EAST PRESTON PARISH COUNCIL

20th February 2020

Re: EP/168/19/PL, 4 Beechlands Cottages and land adjacent, Beechlands Close, East Preston

South Elevation (Front)

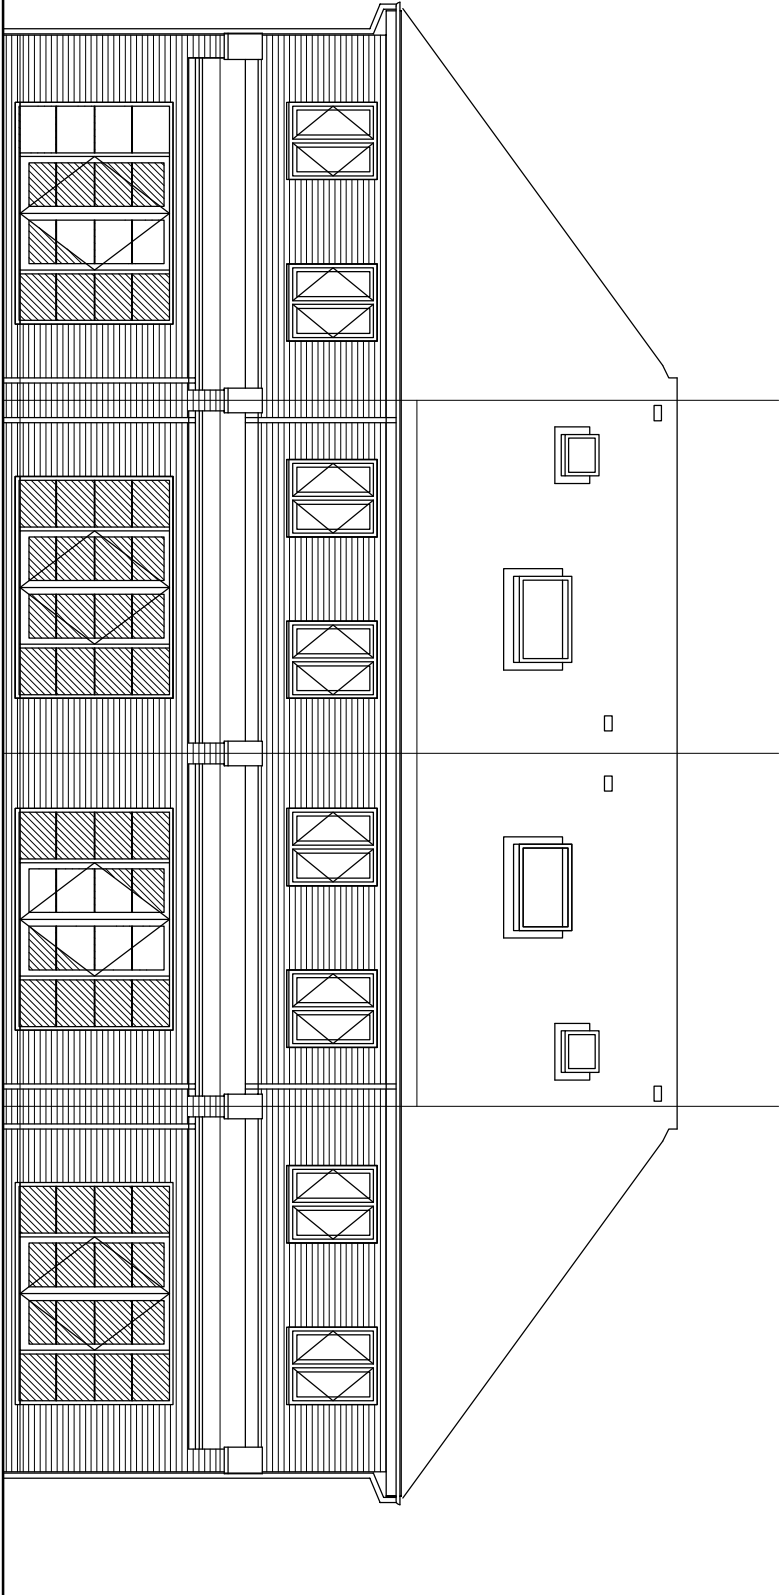
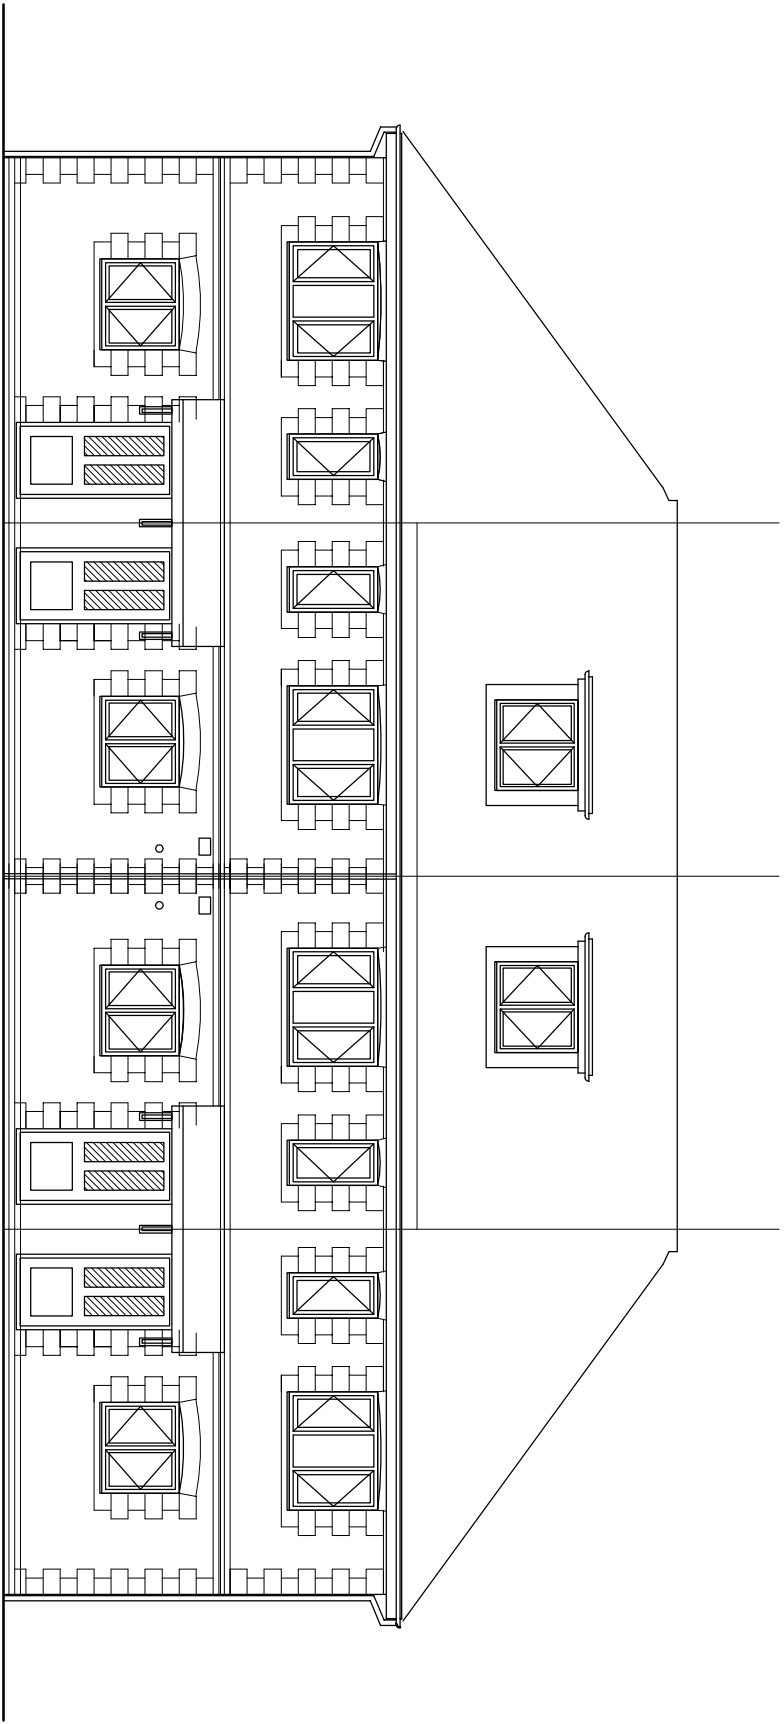
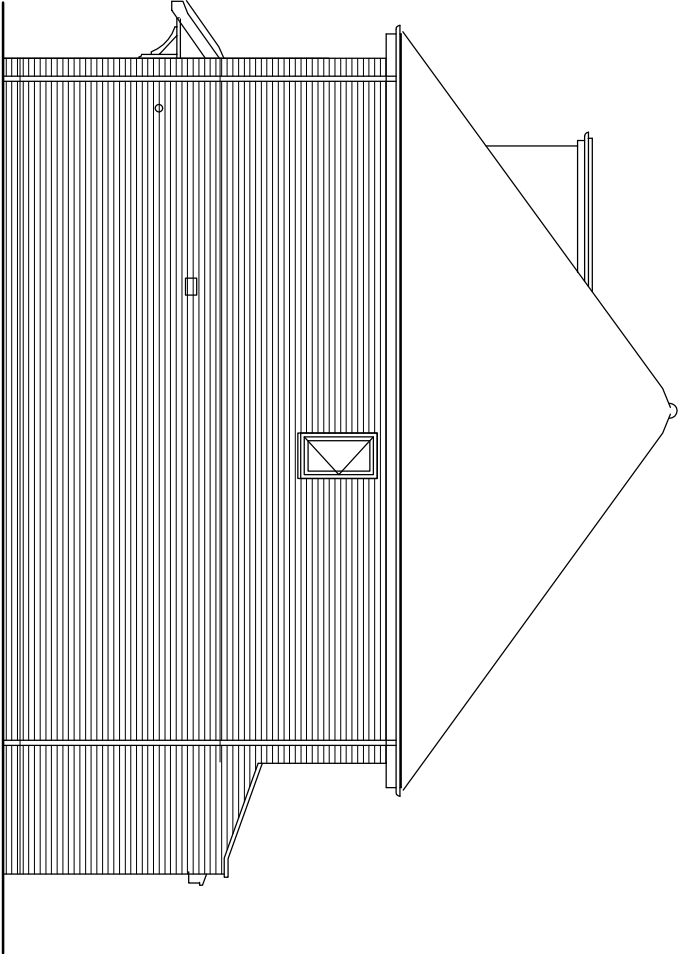
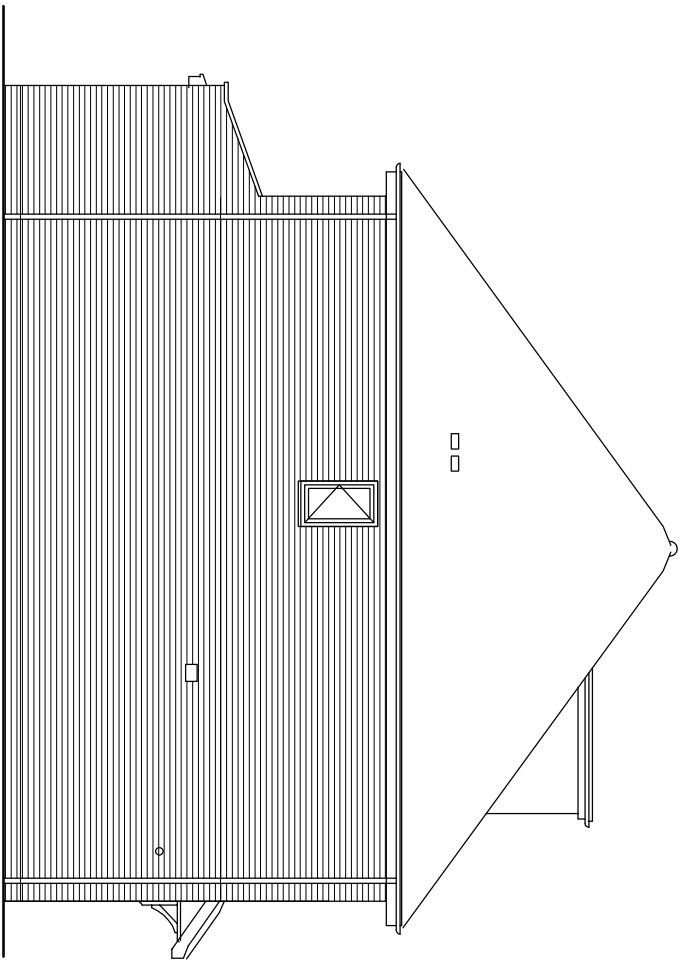
The proposed new property, added to the eastern end of the existing terrace of four, relatively new properties, will result in an unbalanced structure with the roofline treatment at the eastern end differing from that already existing at the western end. The new property will also be stepped in front of the existing terrace and building line. These factors would result in the new house looking like an obvious addition. The proposal will therefore conflict with the Arun Local Plan as the addition will not be visually integrated with the existing building which is a symmetrical design of four properties. The loft conversion to the existing eastern property will also upset the symmetry of the terrace.

The council does not favour the use of cladding within the village as it is not vernacular and furthermore believes the use of cladding in this property, as opposed to the flint work on the existing terrace of four properties, will leave the property looking out-of-keeping with the rest of the terrace. Furthermore, the property will also look out-of-keeping as it will not have an entrance door at the front. The council was further concerned about the narrow gap between the south-eastern corner of the property and the fence line – is it necessary for the property to come in front of the established building line of the existing four properties?

DRAWING TITLE			
Proposed Site Plan Block and Location Plans			
DATE	SCALE	DRAWN BY	GIM
Sept 2016		CHECKED BY	
JOB NO.	DRAWING NO.	REVISION	
1671	2.03	B

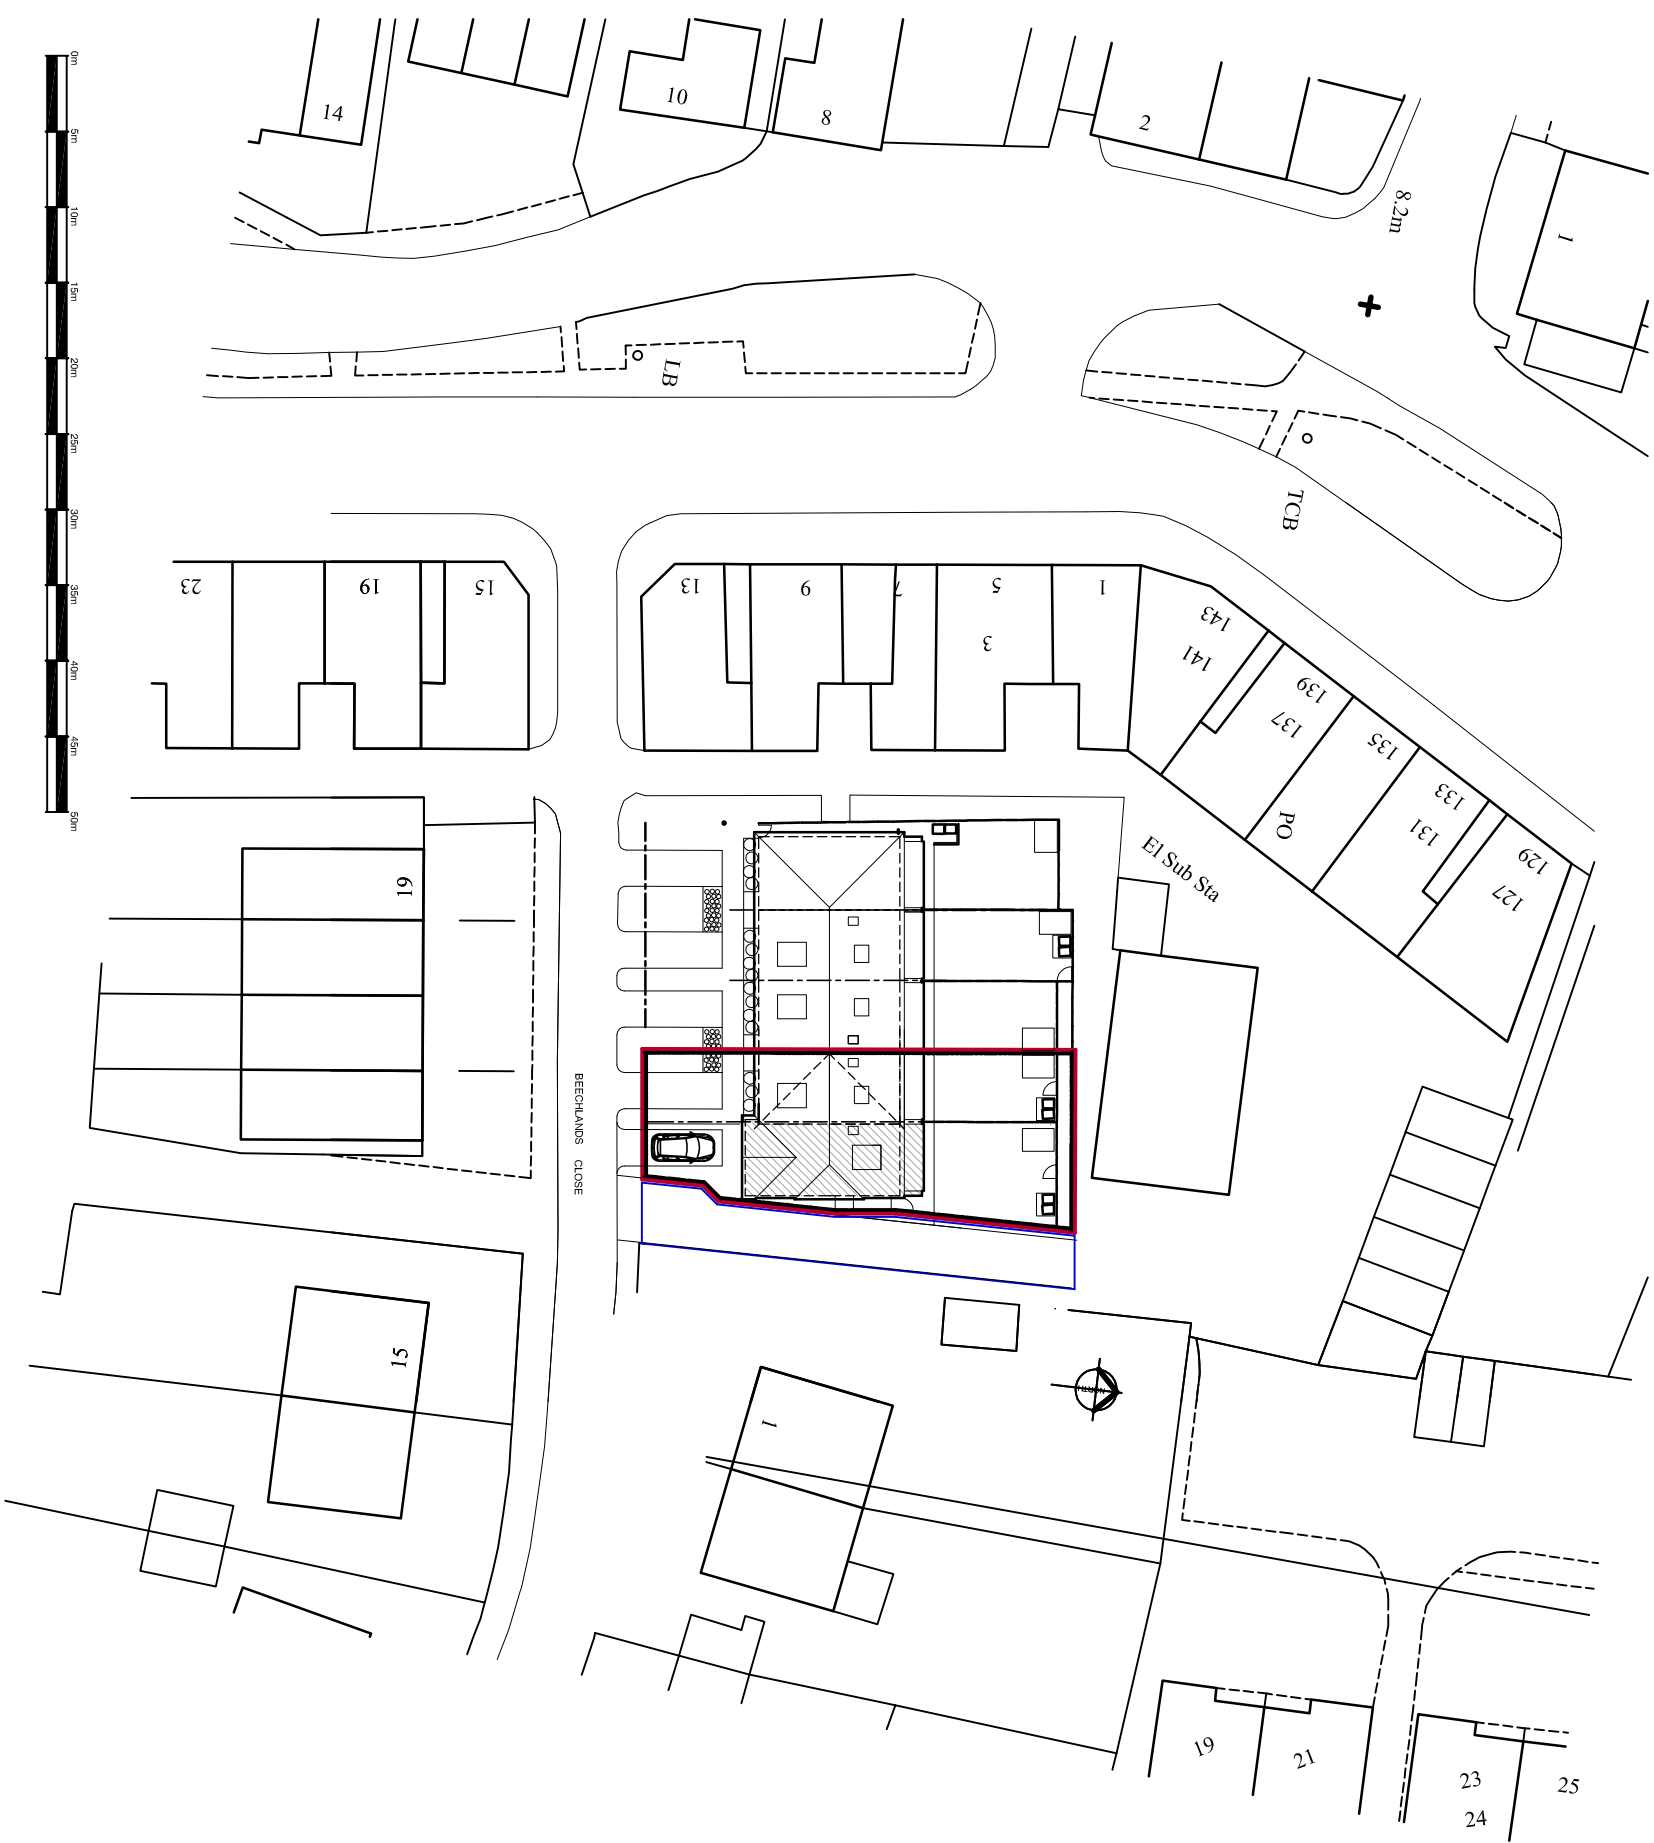
Although the council has seen the response from West Sussex County Council Highways it remains concerned the narrowing of the driveway to the land to the north of Beechlands Cottages will prevent large vehicles using the driveway to deliver goods to the rear of the convenience store in North Lane and this will lead to an increase in large-vehicle deliveries taking place in the service road to the immediate northwest of Beechlands Cottages. This is a narrow service road and large delivery vehicles already cause a certain amount of hassle there. Residents present at the committee's meeting said lorries already have some difficulties with the current width of the driveway.
